From: Andrew Wood
Sent: 08 May 2019 12:12
To: Planning.Responses
Subject: FW: M/24/19/PL - 3 The Hard, Elmer
Attachments: 789 PL001 Proposed Floor Plans Site and Location Plans REV A.pdf; 789 PL002 Proposed Elevations and Sections REV A.pdf

From: Michael Wood [REDACTED]
Sent: 26 April 2019 08:48
To: Andrew Wood
Subject: M/24/19/PL - 3 The Hard, Elmer
Importance: High

I respect of the above application and in response to the comments raised by the Environment Agency in their consultation, please find attached amended drawings PL001 A and PL002 A indicating the existing raised bund running east west across the site as being retained.

A	EAST WEST BUND TO GARDEN RETAINED	23.04.19
REV	DESCRIPTION	DATE
PROJECT		
REPLACEMENT DWELLING		
3 THE HARD		
ELMER SANDS		
WEST SUSSEX		
CLIENT		
Ms D HUANG		
DRAWING TITLE		
PROPOSED ELEVATIONS, ROOF PLAN		
& SECTIONS		
SCALE	DRAWN BY	DATE
1:100 @ A1	MW	JAN 19
DWG NO	PLO02	REV. A

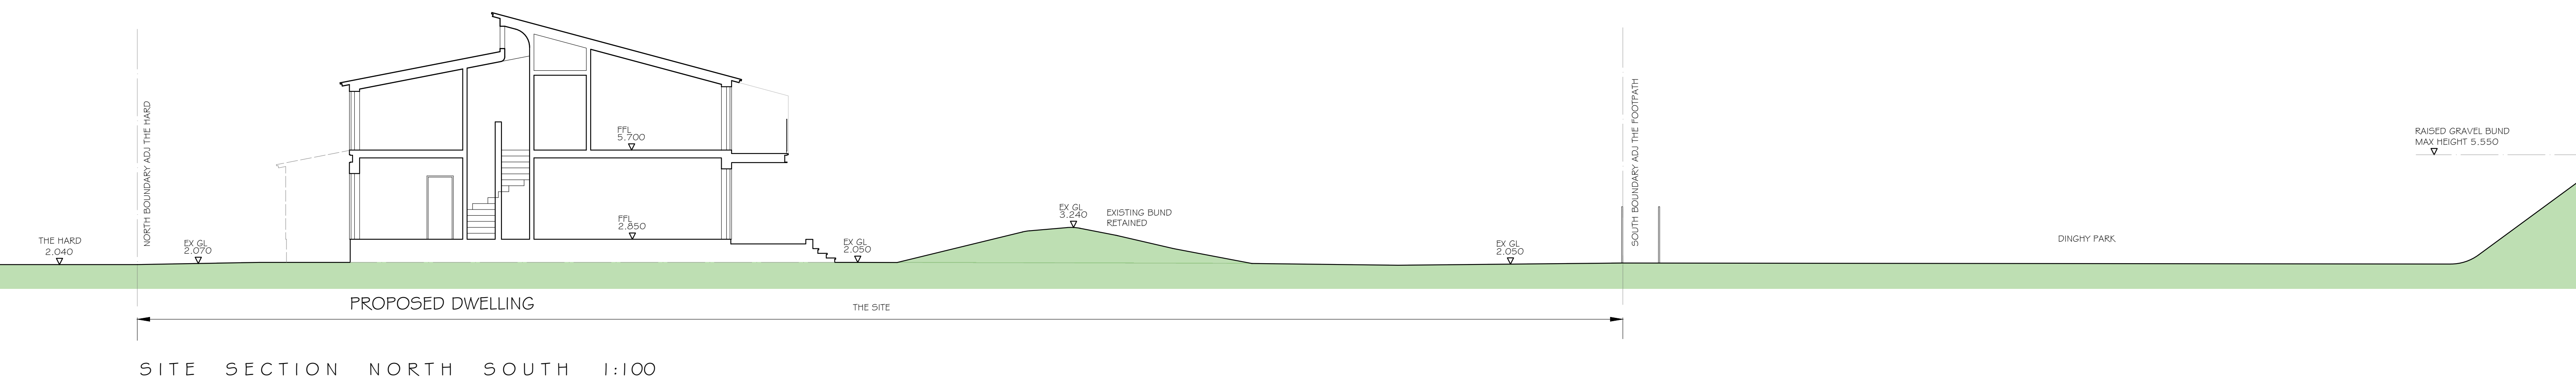
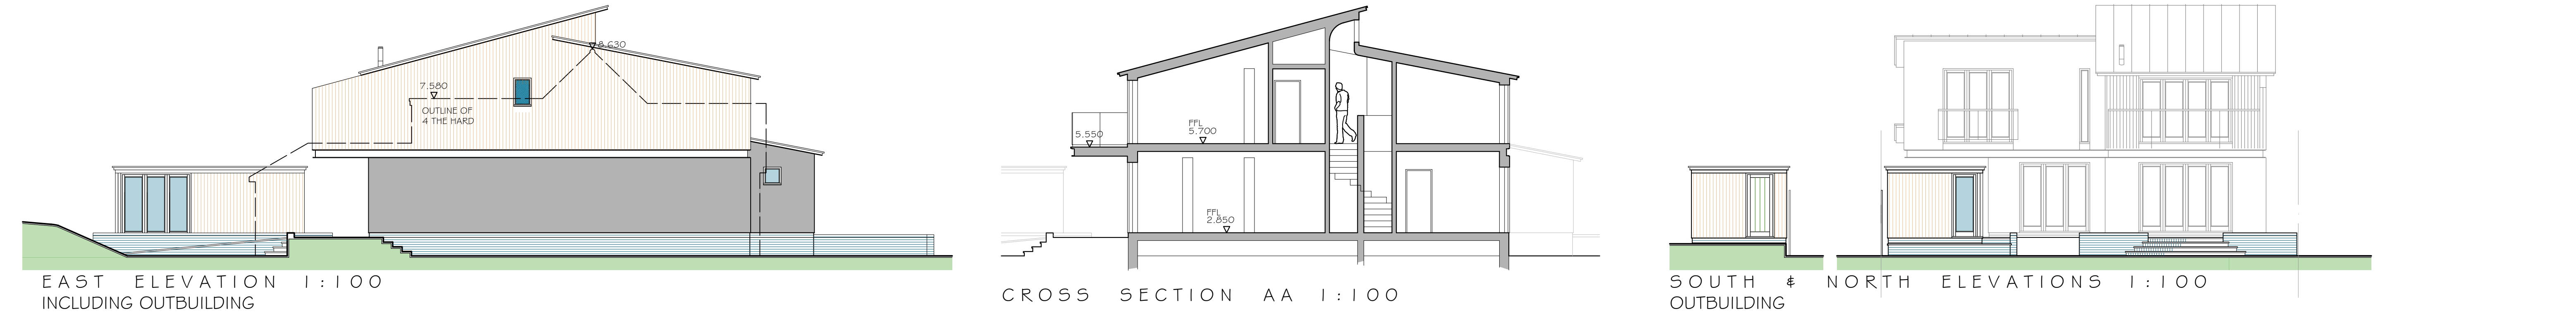
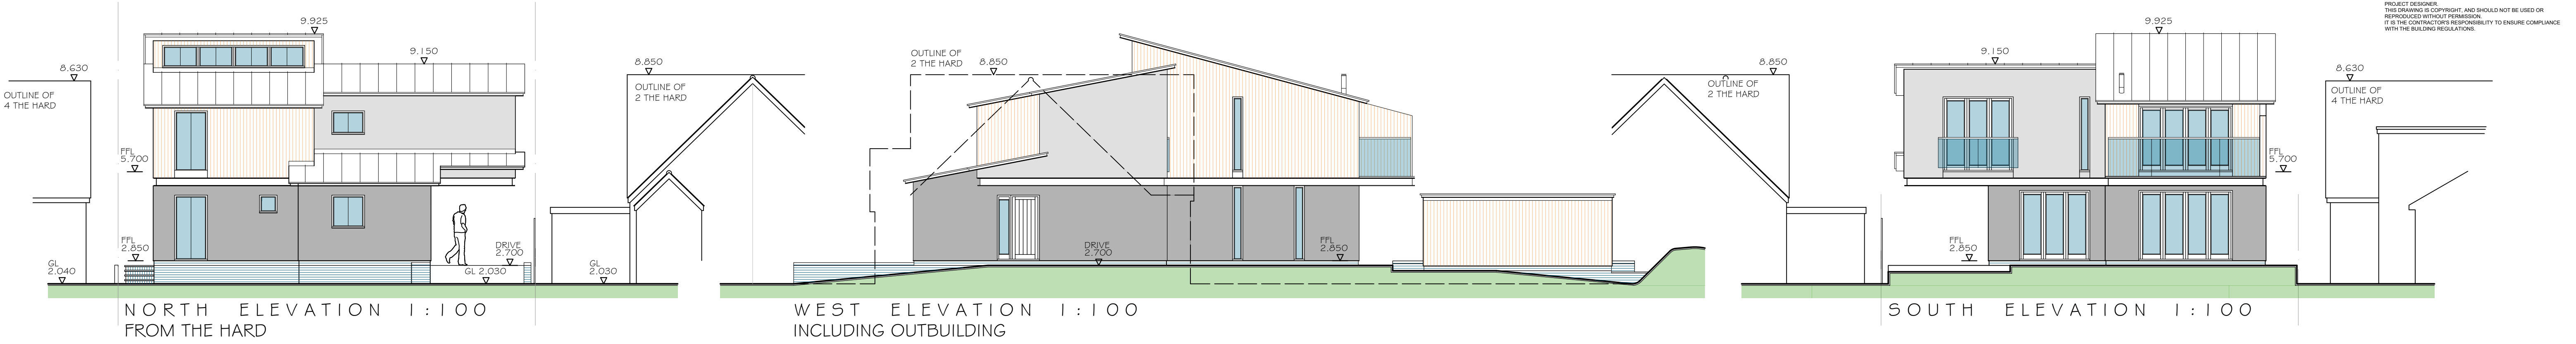
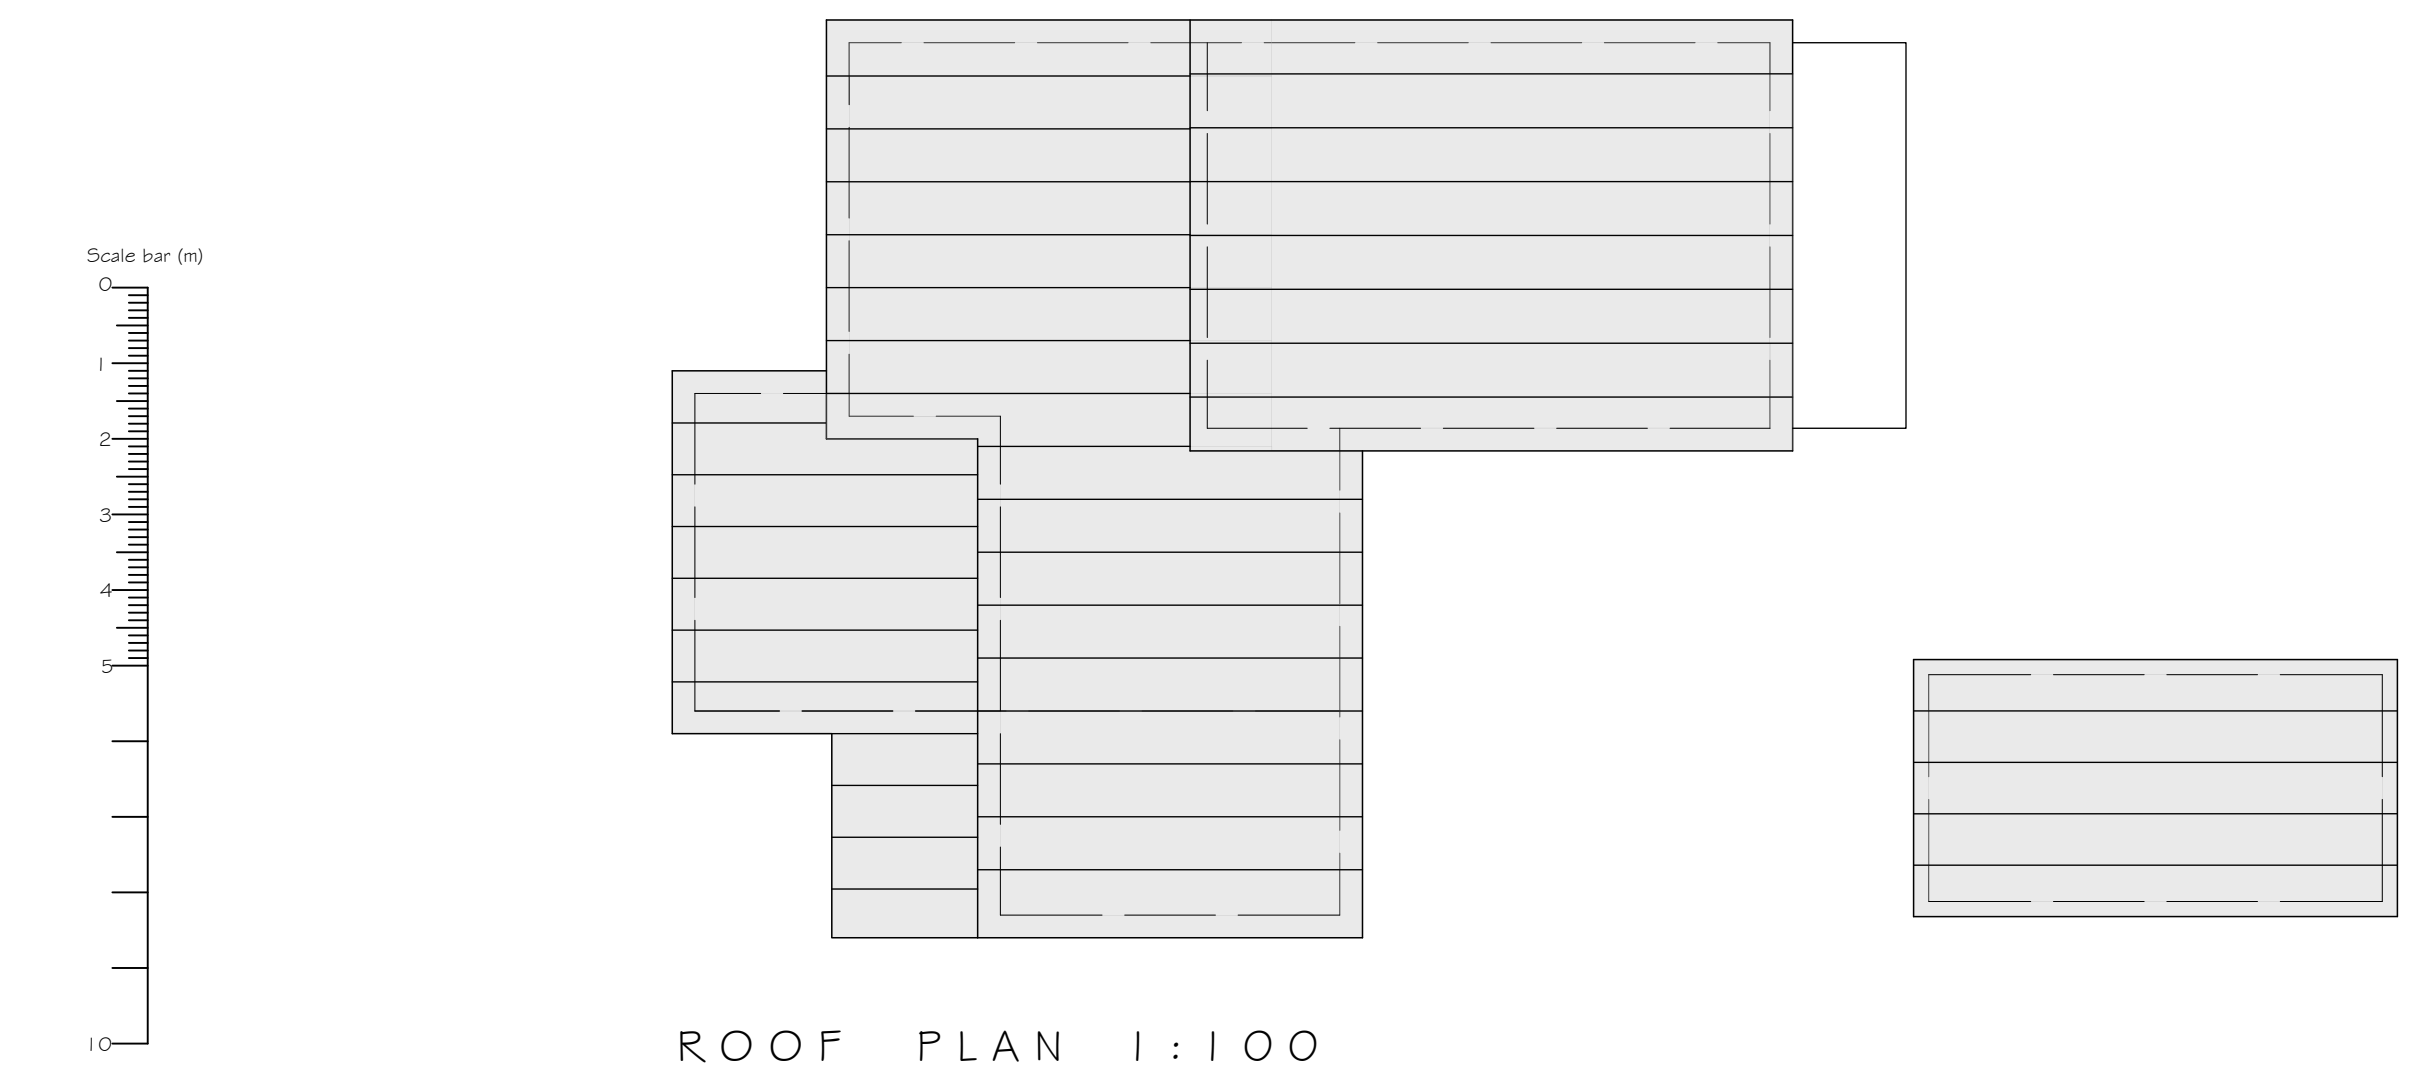
Please note the amended plans showing the retention of the secondary flood defence bund in the rear garden.
